## **NEWRIVER, FOUR ASHES PUBLIC HOUSE, FOUR ASHES**

### **APPLICATION BY FOUR ASHES LIMITED FOR AN ORDER GRANTING DEVELOPMENT CONSENT FOR THE WEST MIDLANDS INTERCHANGE**

### **CONNECT TECHNICAL NOTE 03 – OBJECTION ON BEHALF OF NEWRIVER TO PROPOSED RIGHT TURN BAN AT THE A449 STAFFORD ROAD / STATION ROAD JUNCTION**

**21<sup>ST</sup> AUGUST 2019**

- 00 Total Vehicles
- (0) HGVs
- Site
- New road

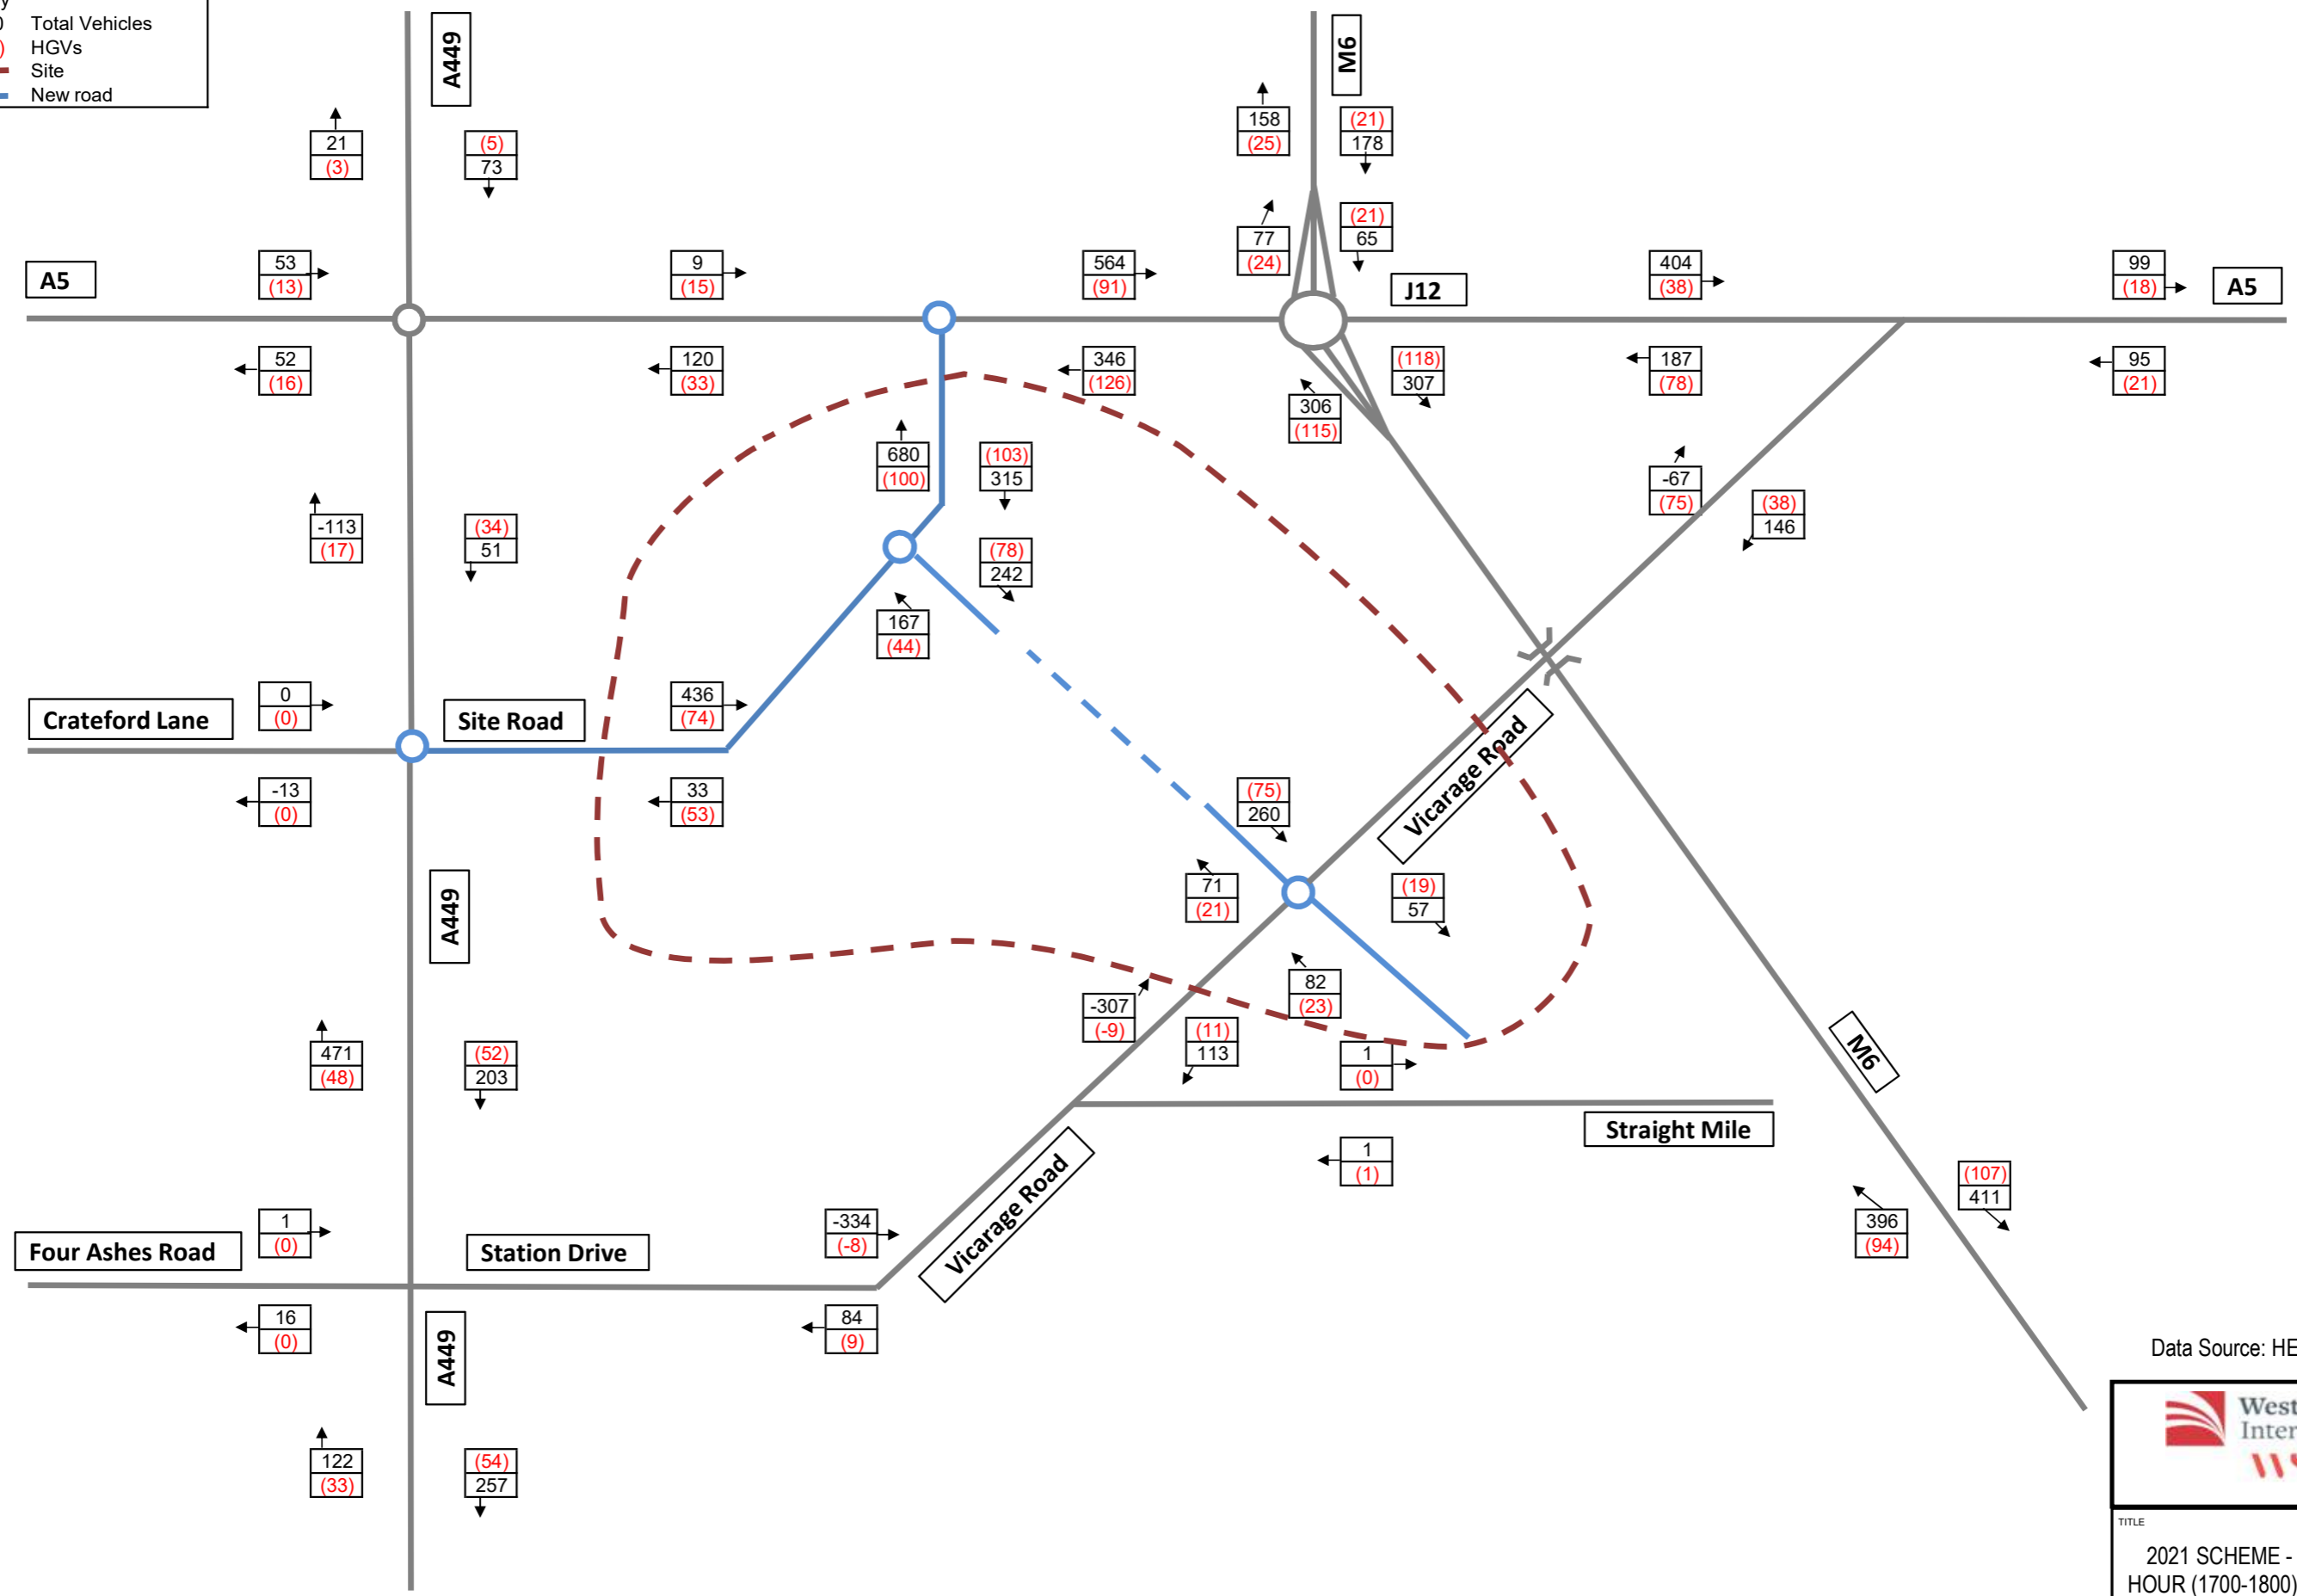
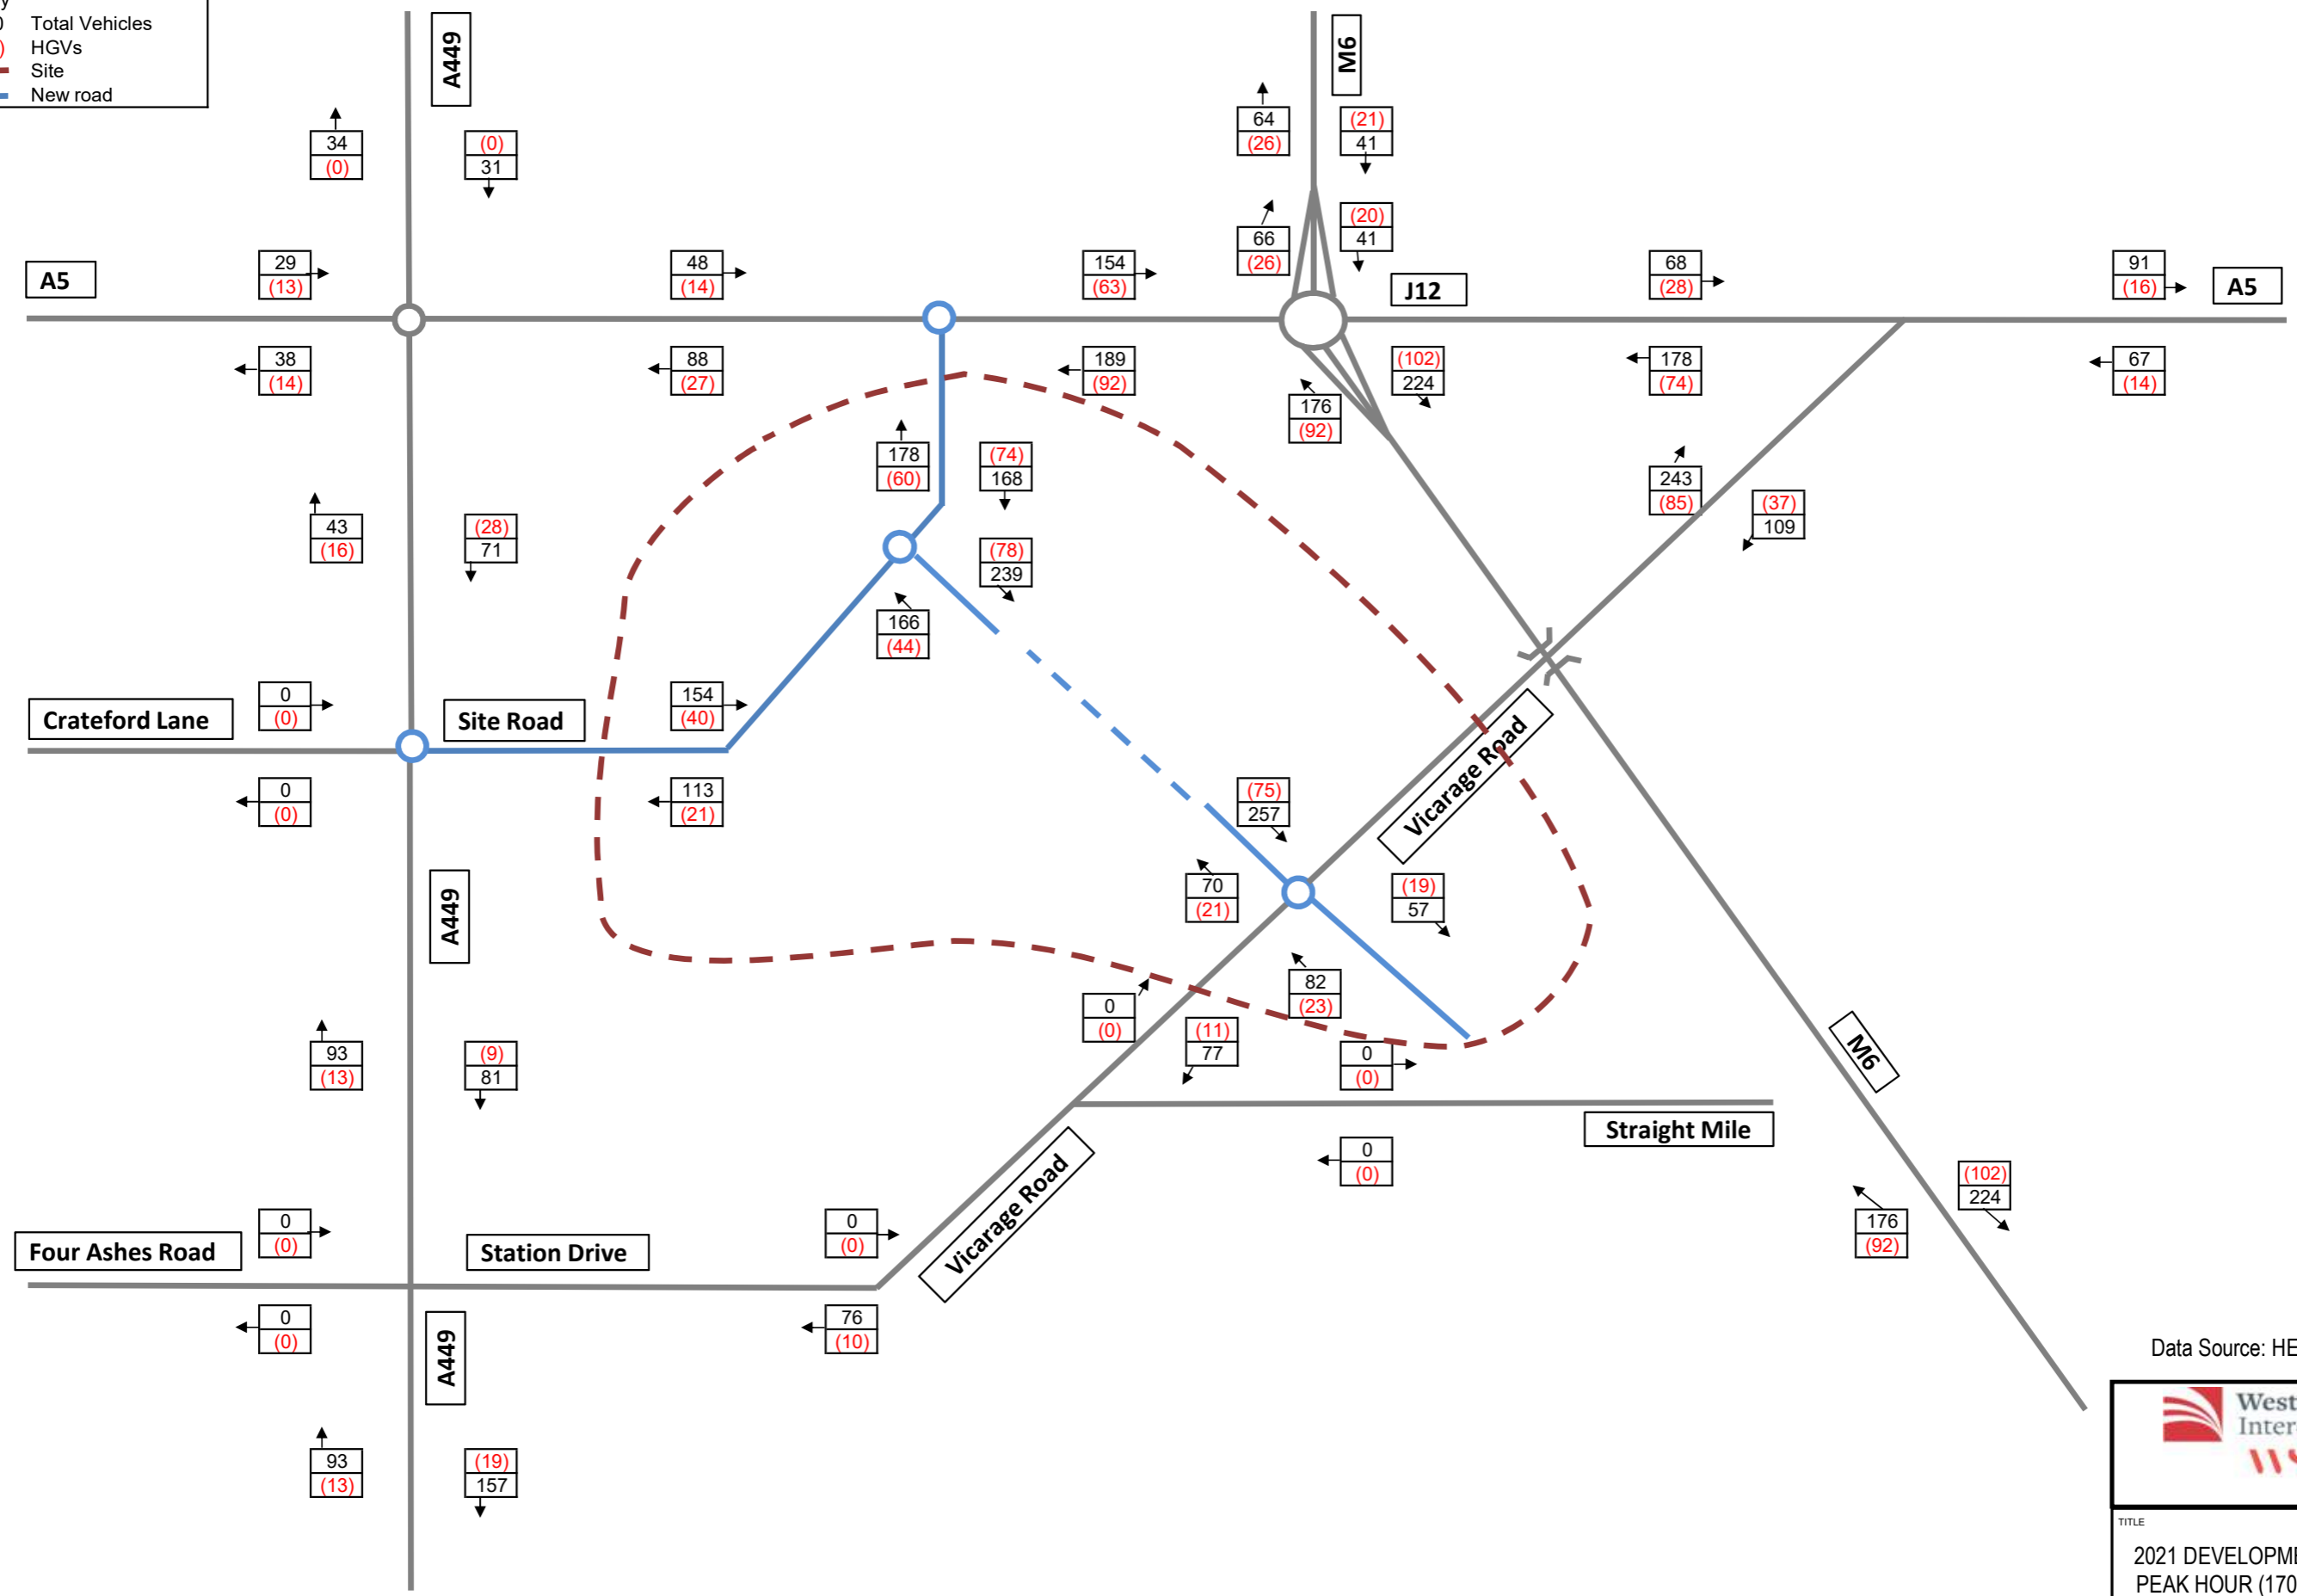
- WSP have still not presented accurate traffic flow diagrams (i.e. including U-turns at junctions) which raises questions regarding transparency.
  - Paragraph 2.5: WSP appears to be making a (diversionary) semantic argument relating to the meaning of "reduce", with the assertion that "remove" is not a subset of "reduce". This is equivalent to saying that any of the numbers one to nine are less than ten, but zero is not.
